Arun District Council
Development Control
1, Arun Civic Centre Maltravers Road
Littlehampton
West Sussex
BN17 5LF

Our ref: HA/2009/108487/03-L01
Your ref: FP/109/11/
Date: 29 July 2011

**ERECTION OF 1 NO BUNGALOW WITH ASSOCIATED PARKING AND
EXTERNAL WORKS (RESUBMISSION OF FP/241/10/)
21 UPPARK WAY BOGNOR REGIS**

PROPOSED SITE AND ROOF PLAN

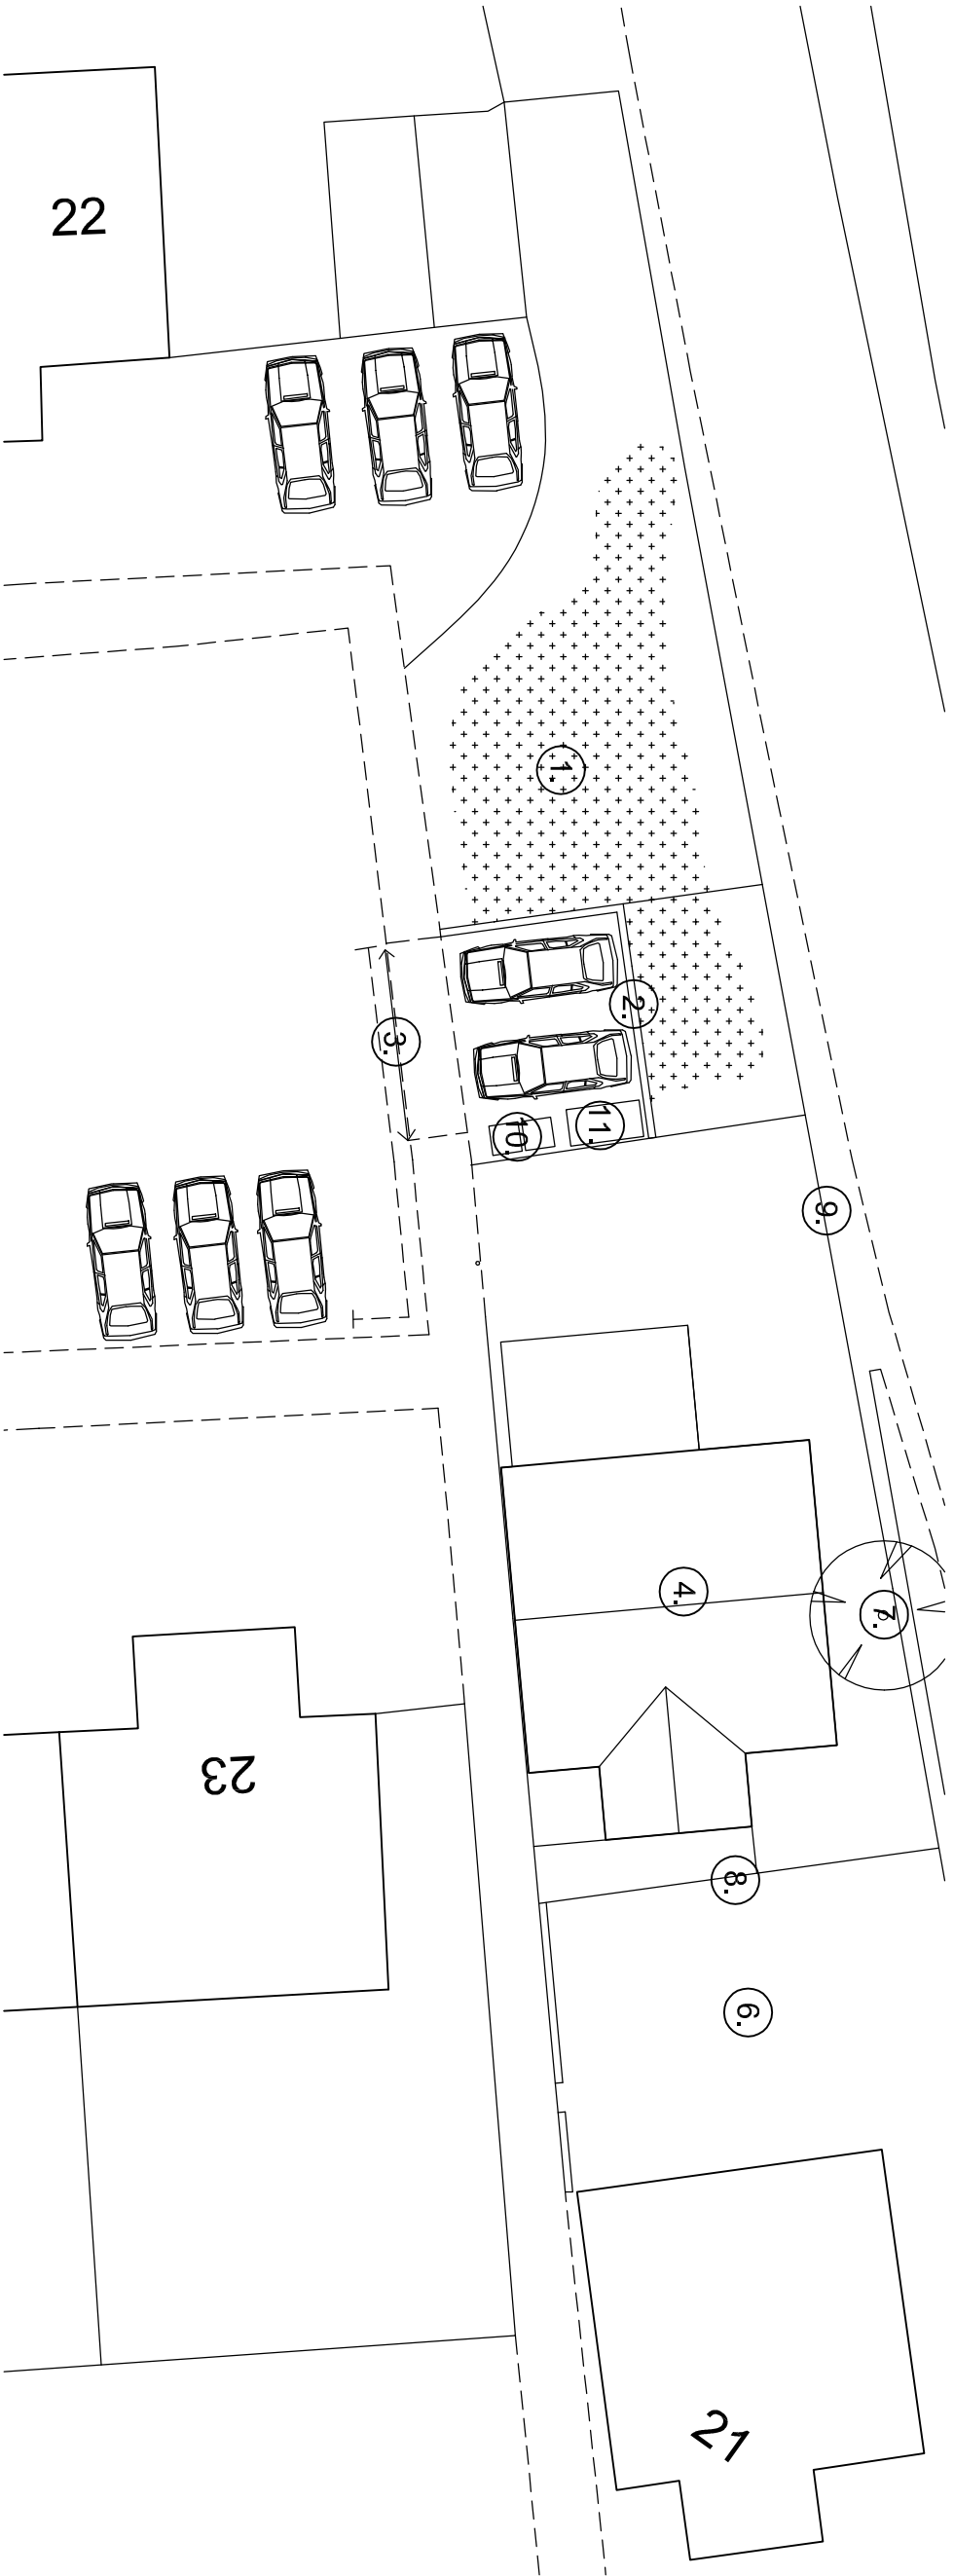
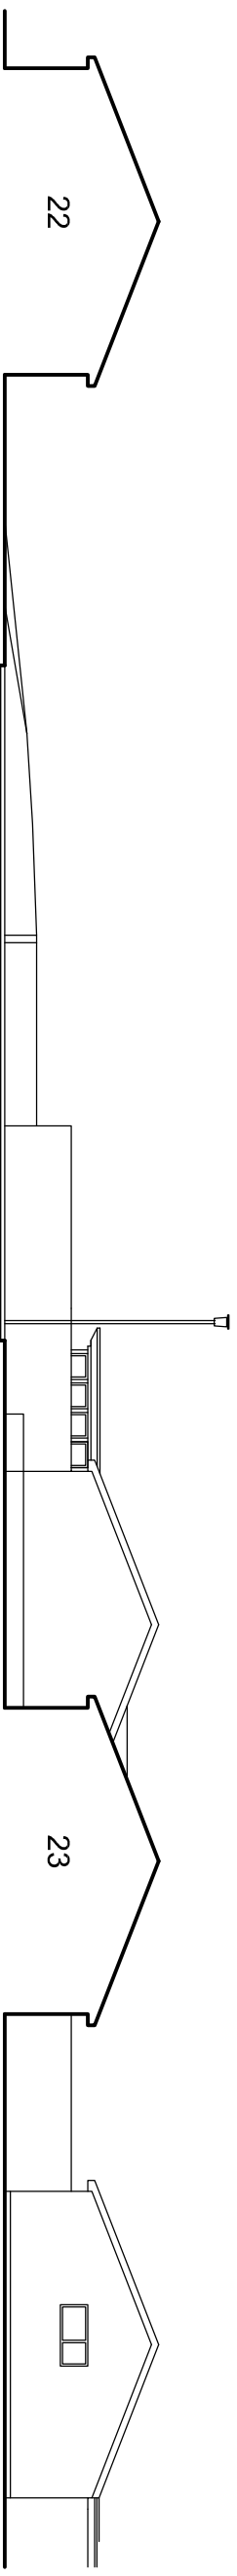
The proposed development will only be acceptable if the following measure(s) as detailed in the Flood Risk Assessment submitted with this application are implemented and secured by way of a planning condition on any planning permission.

The development permitted by this planning permission shall only be carried out in accordance with the approved Flood Risk Assessment (FRA) and the following mitigation measures detailed within the FRA:

Finished floor levels will be set no lower than 200mm above existing ground level.
